Ref: EN020026

18th November 2025

Application by National Grid Electricity Transmission (NGET) for an order granting development consent for the South East Anglia Link (Sea Link) Project

Examination Authority Written Representation - deadline 1 (18th November 2025)

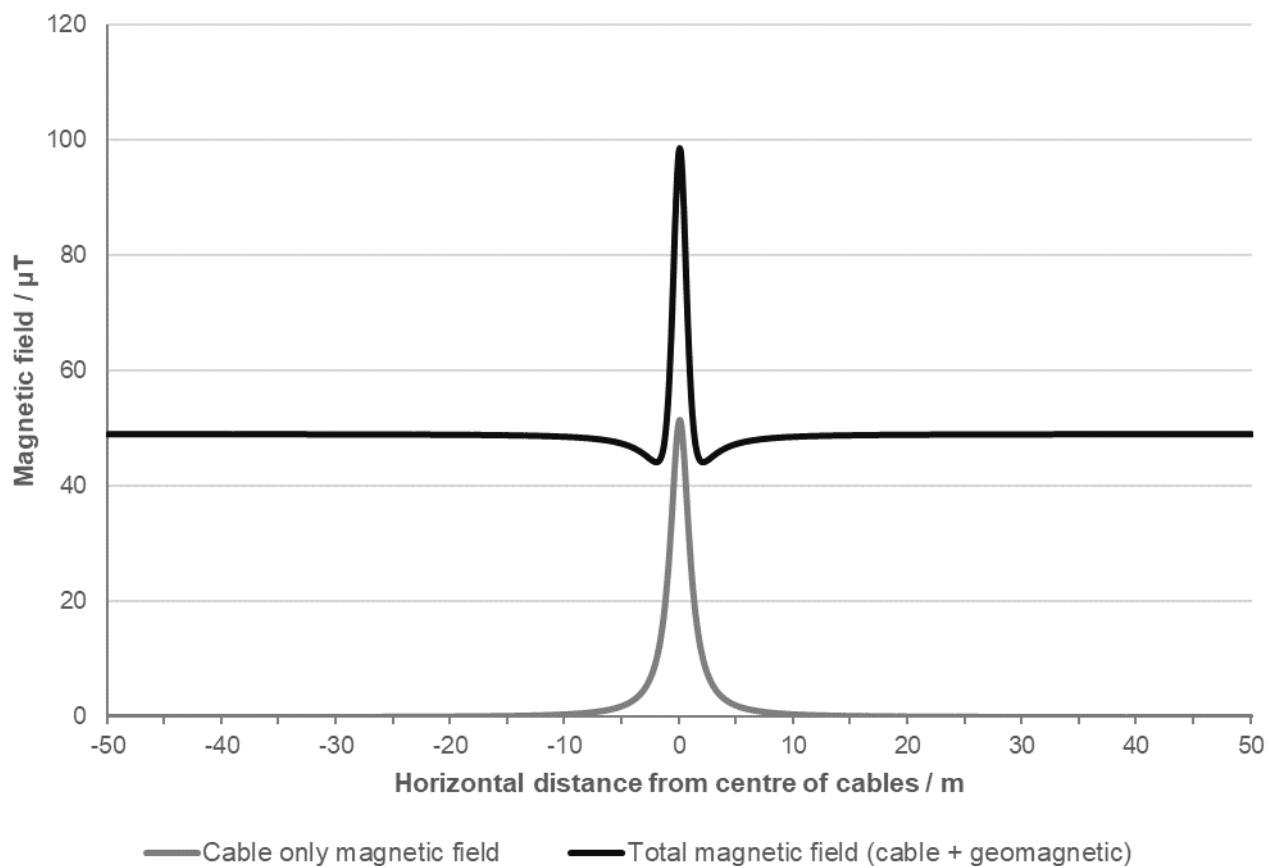
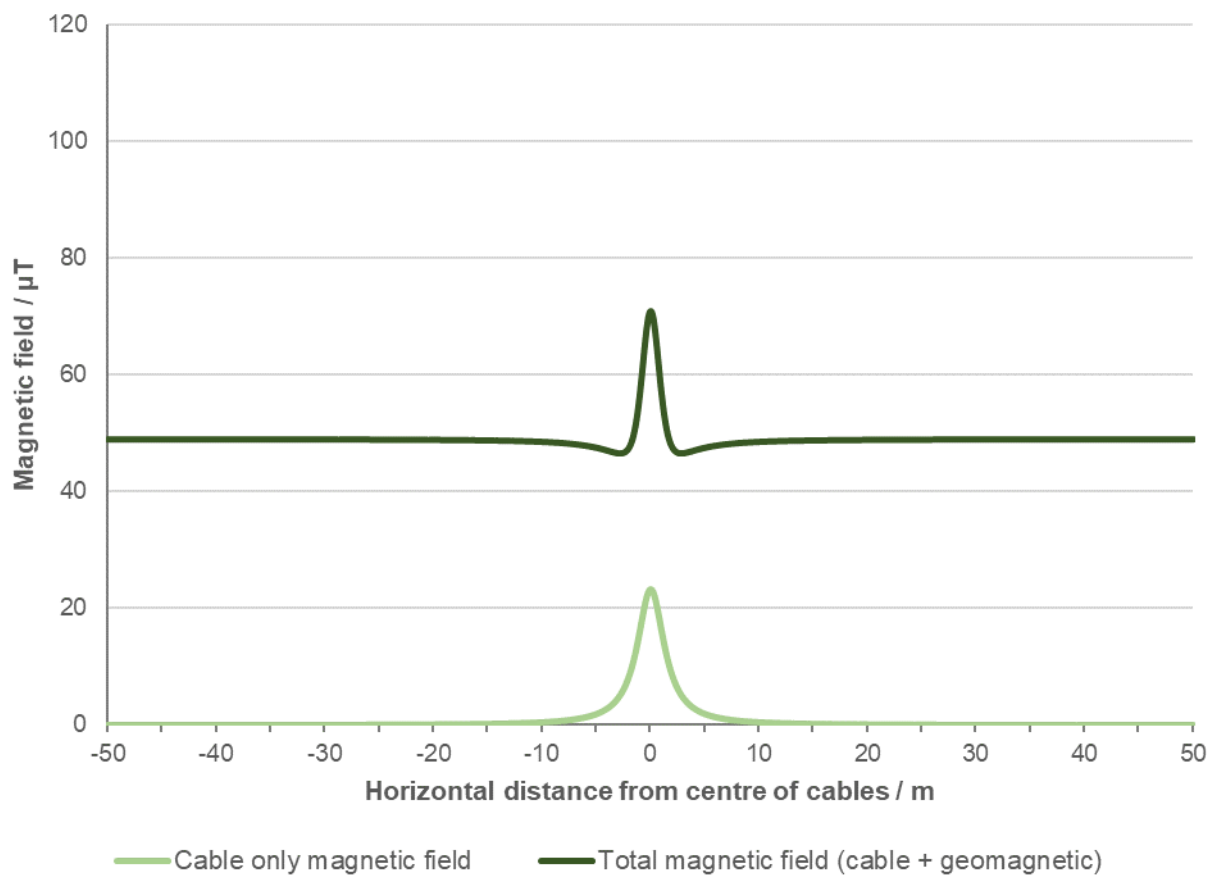
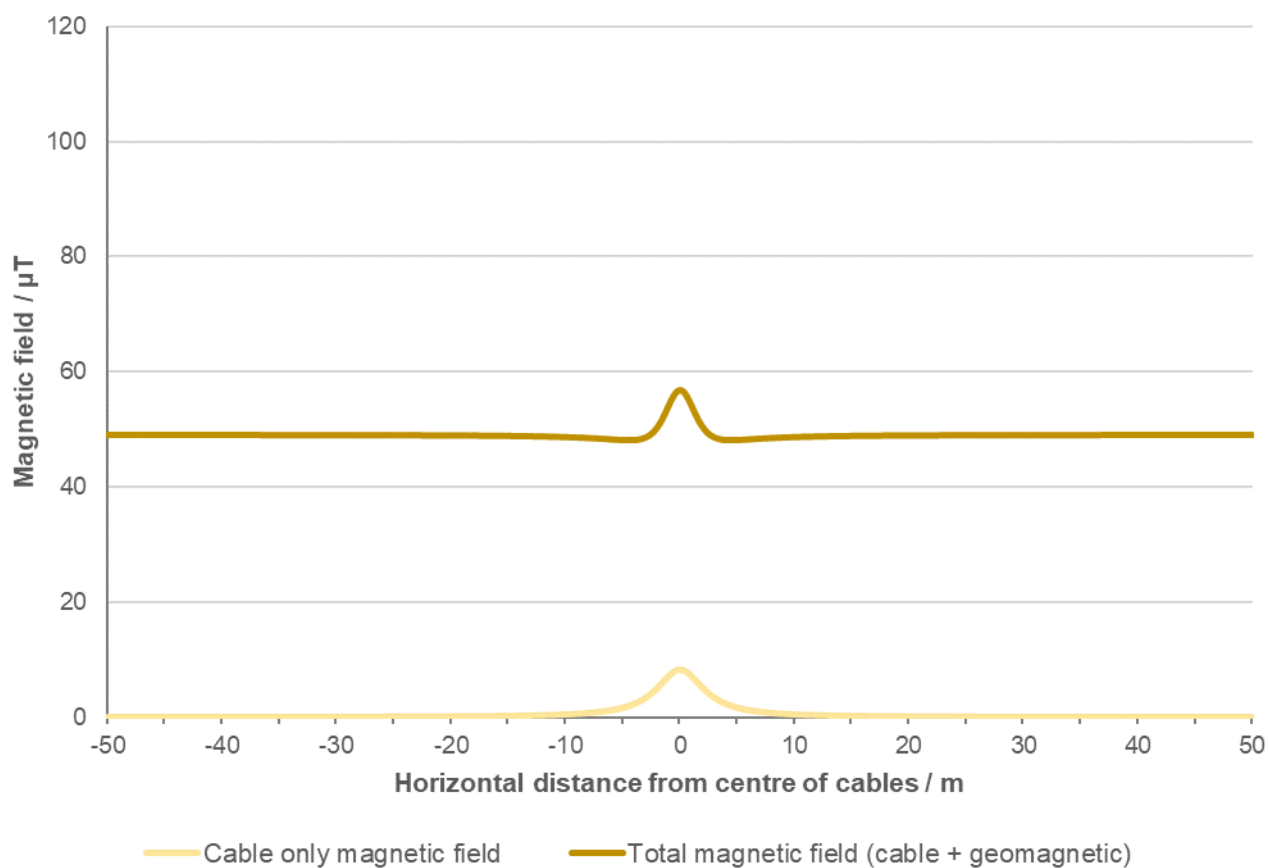
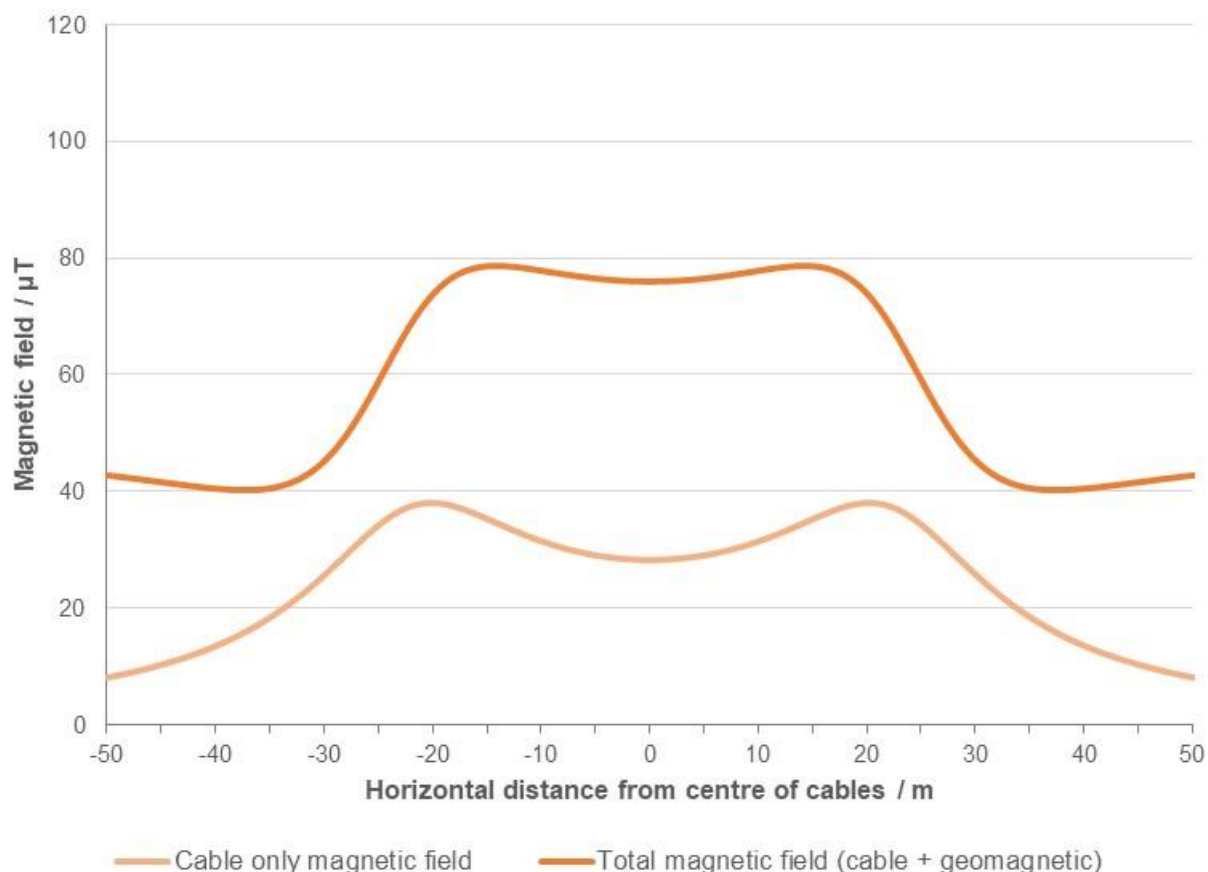
The MCA confirms that the offshore section complies with our requirements; less than 3° deviation for 95% of the route and less than 5° for the remaining 5%, as detailed in Table 5.2 of the Electric and Magnetic Field Compliance report. In nearshore areas where the cables are separated by 45m and buried to a depth of 10m (approximately 2.435 km in total—1.524 km along the Suffolk coast and 0.911 km in Pegwell Bay), no detailed EMF assessment has been provided. While this segment represents only 2% of the total route and vessel traffic is mostly perpendicular (minimising interaction), the separation may result in compass deviations exceeding 5°.

Although the navigational impact is expected to be minimal, the MCA requests that the project team ensure maximum burial depth throughout the trenchless phase and to consider bundled lay as much as practically possible to further reduce any potential EMF effects on vessel navigation. Should anything change with the current cable route, and it cannot be demonstrated that MCA deviation requirements can be met pre-construction, MCA should be consulted, and a post-construction compass deviation survey of the 'as laid' Offshore Cable Corridor may be required.
